Planning Application No: 3/2024/0785

Proposal: Proposed demolition of conservatory, and single storey side extension, and construction of single-storey extension to rear and two-storey extension to side.

Location: 2 Lane Ends Simonstone Road Sabden BB7 9EZ

Block plan - 1:200

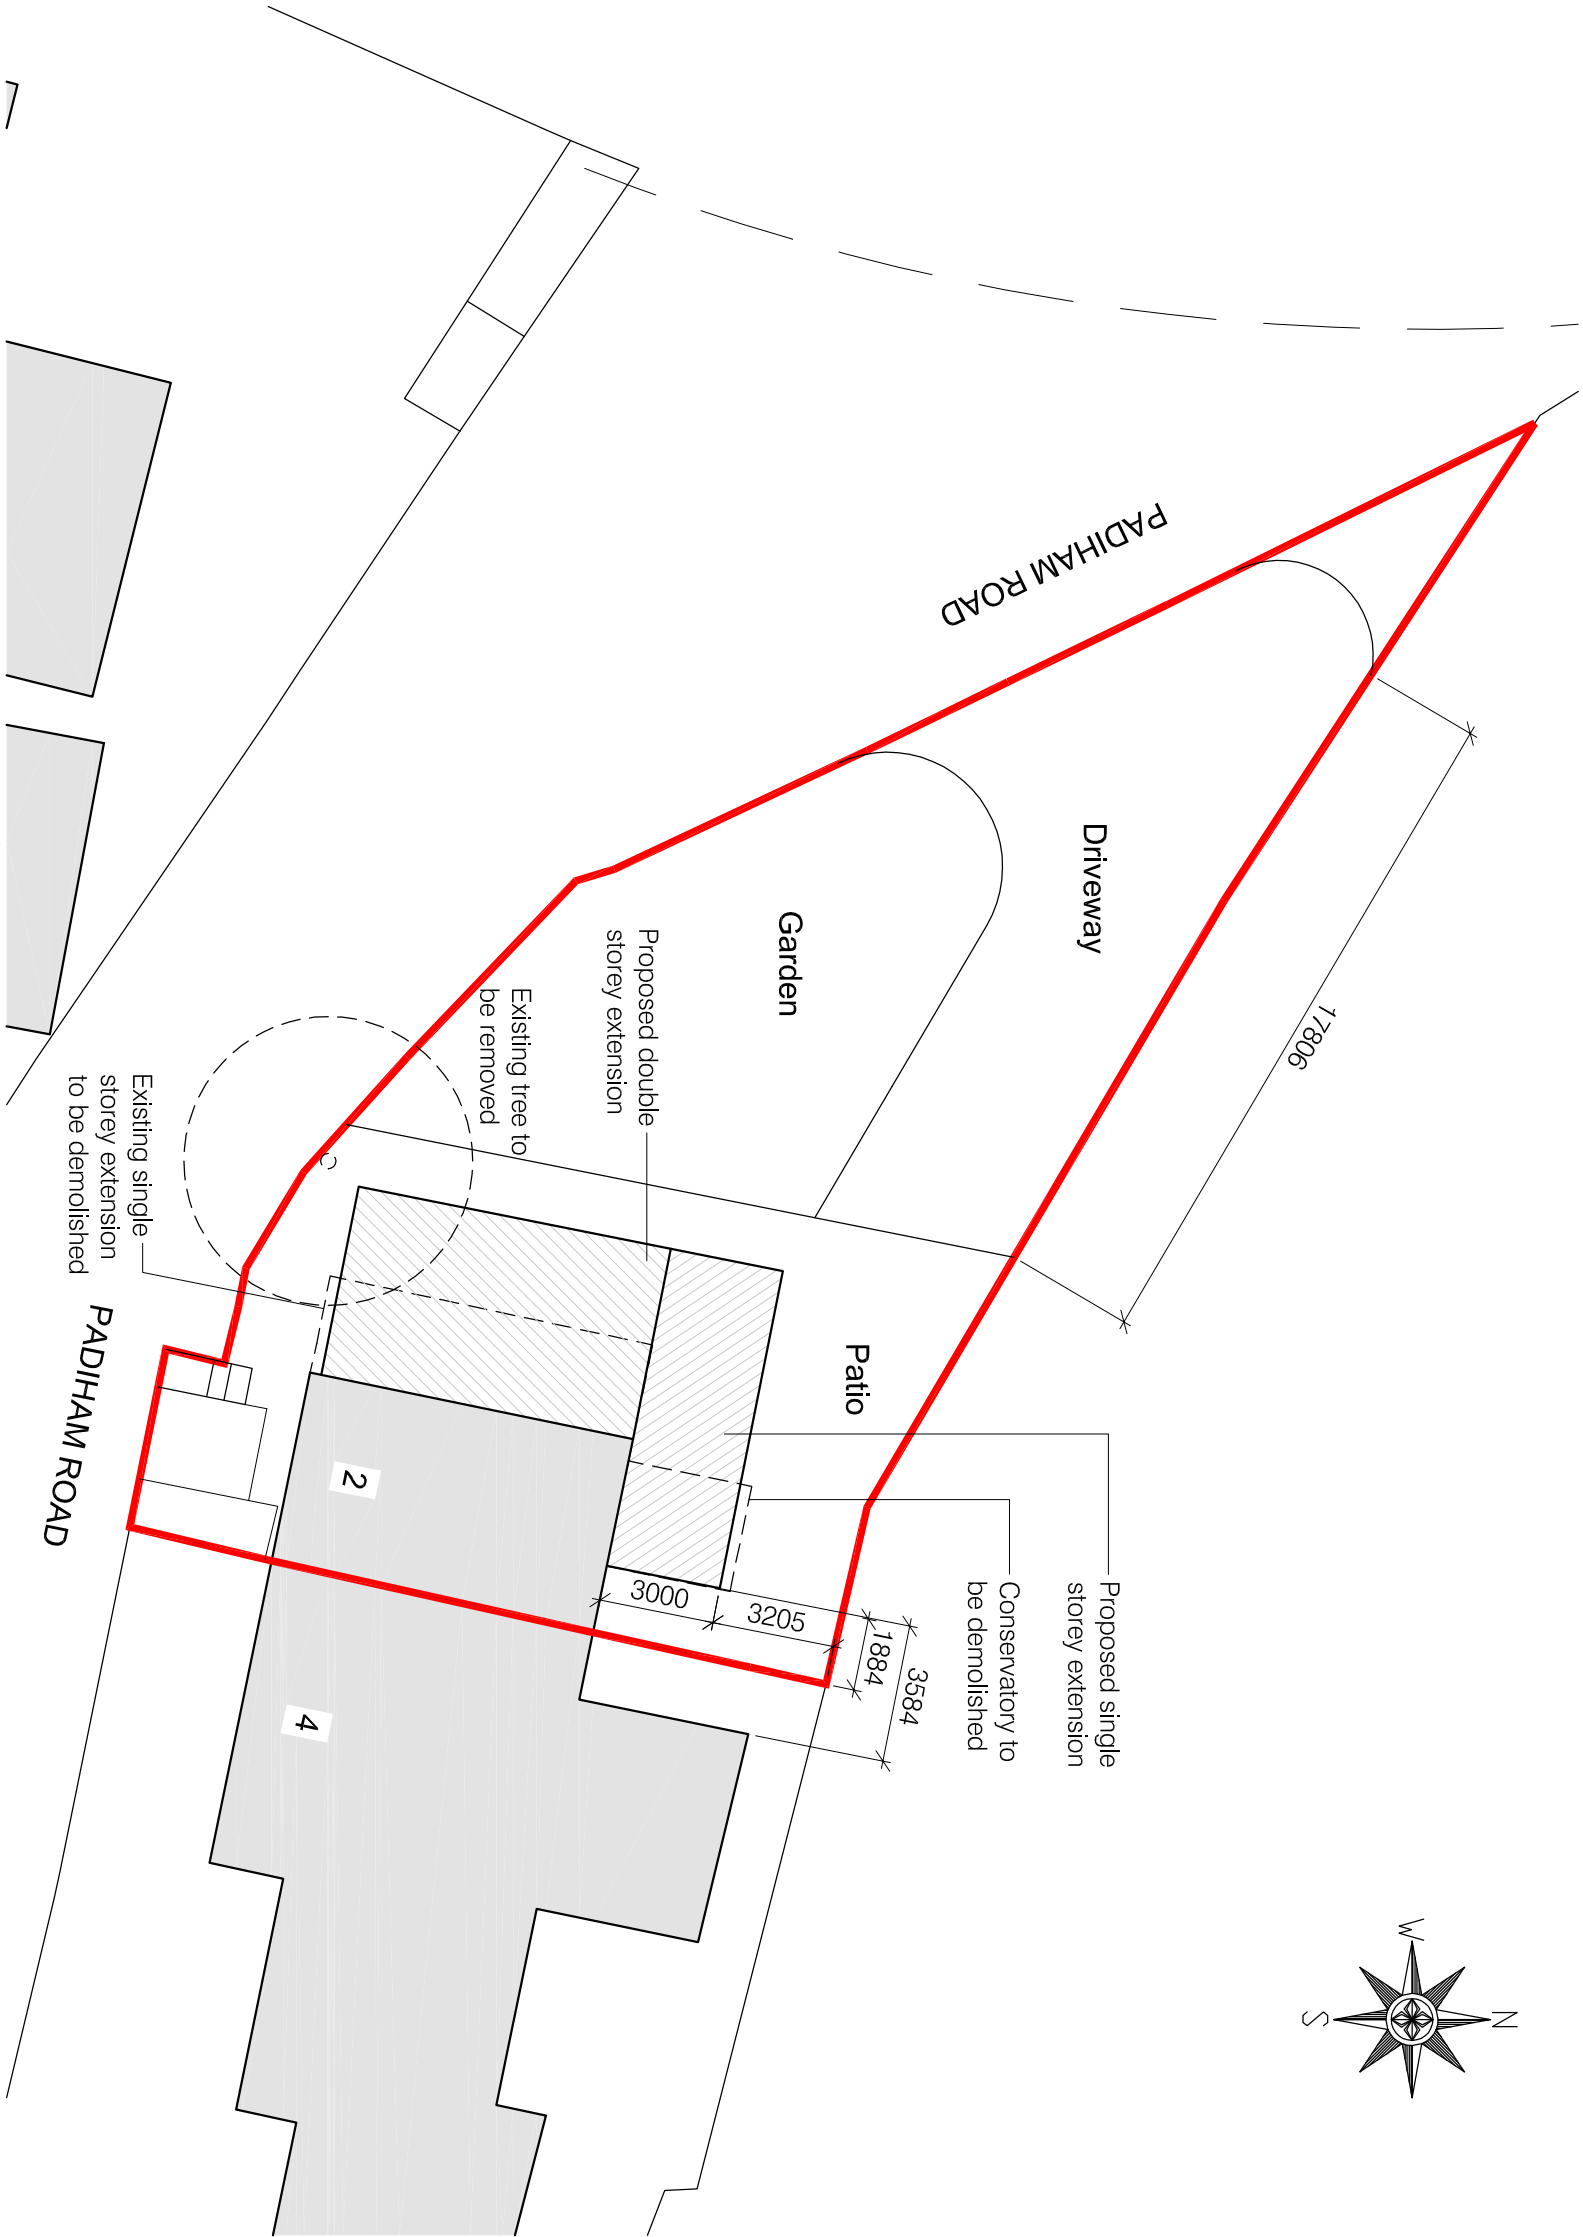
There no mention of the number of existing or proposed bedrooms and no parking plan has been submitted. Please ensure that parking standards can be met for this size of proposal; if 3 parking spaces can be provided within the curtilage for a proposed 4+ bedroom property then there is no objection. However, as Padiham Road has a 60 mph speed limit (minor road) leading off Simonstone Road then the following condition is required to alleviate any highway safety concerns during the construction process.
